DEVELOPMENT FACILITATIVE TEAM (DFT) Code Enforcement Comments

DATE: 1/25/2023

SI-2023-00132 – SITE PLAN DFT

REQUEST: SITE PREPARATION, CONCRETE FOUNDATIONS, BASIC UTILITIES FOR 3 NEW DETACHED BUILDING. PROPOSED BUILDINGS ARE AN EXPANSION TO EXISTING KAIROS POWER CAMPUS TO BE USED FOR LIGHT MANUFACTURING/ OFFICE USES.

SITE PLAN

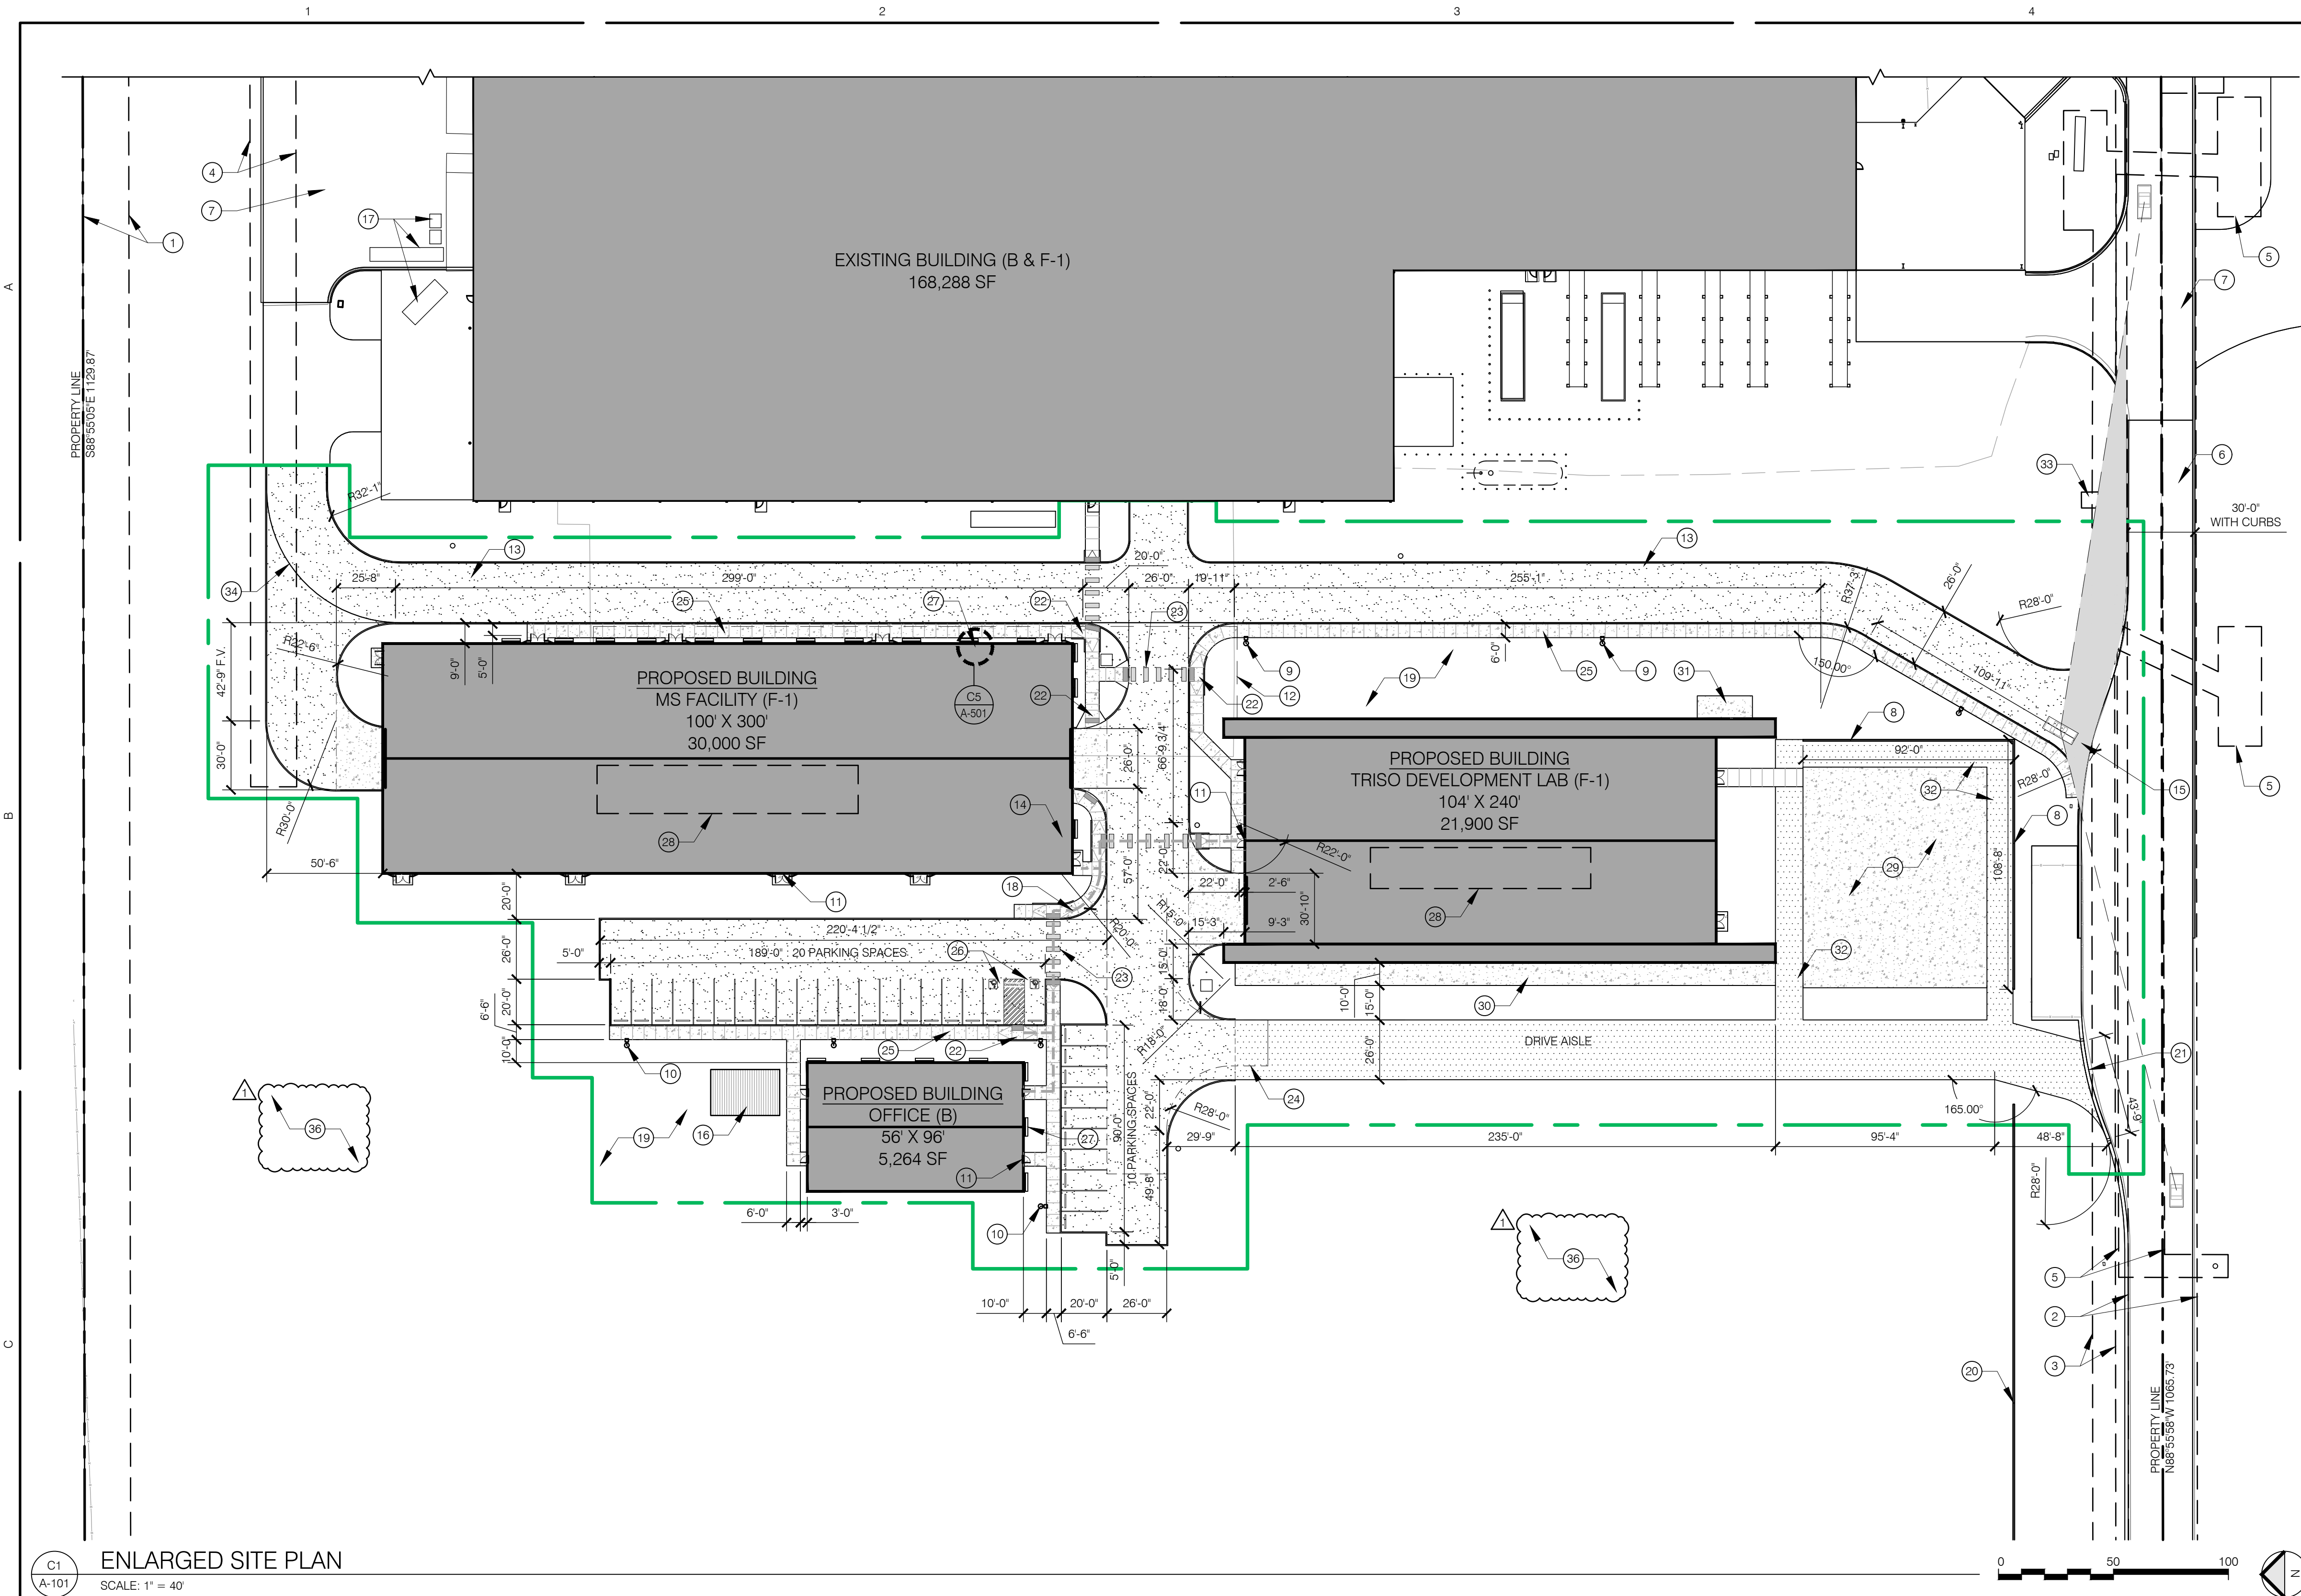
1. As noted in the submittal, proposed development must meet requirements of the Mesa Del Sol Master Plan and obtain ARC approval, accordingly. Where the MDS Plan is silent, proposed development must meet applicable requirements of IDO, DPM, or other adopted City regulations.
2. Show how parking calculations have been determined on page A-100 of Site Plan, breaking out required for each use outlined (office, manufacturing, and any other). Calculate per each and provide total required reflecting parking requirements as per IDO 5-5(C), Table 5-5-1, or other standards identified.
3. CE has no further comments at this time.
